Your Ref: OWPC7170
Our Ref: EP/114/15/HH 12-08-2015
Please ask for:
Mr D Easton

Single & two storey extensions
19 Normandy Lane East Preston

Thank you for your internet representation made on 15th October 2015 which has been recorded as '**an objection**' with the comments as follows:

Proposed Front Elevation (East). Scale 1:100

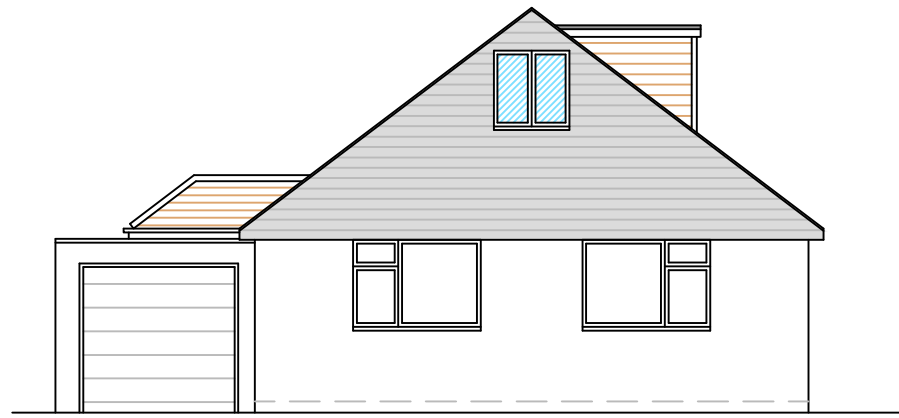
The conversion of the front elevation from a hipped end to a gable end, and enlarging the dormer window on the north side of the roof to run almost the whole length of the building, is contrary to Policies 1 and 3. Policy 1 states in the section on Development Principles that dormer windows should be small enough to be subservient to the appearance of the roof as a whole, which the proposed dormer is not, (paragraph 4.14); and that an enlarged house should harmonise with other houses in the road in scale, design and materials, which the proposed gable end at the front would not achieve.

Policy 3. ii. states that where new rooms are created in a roof space, the basic form of the roof should not be altered. Para. 4.27 states "A hipped roof should only be changed to a gable end at the rear".
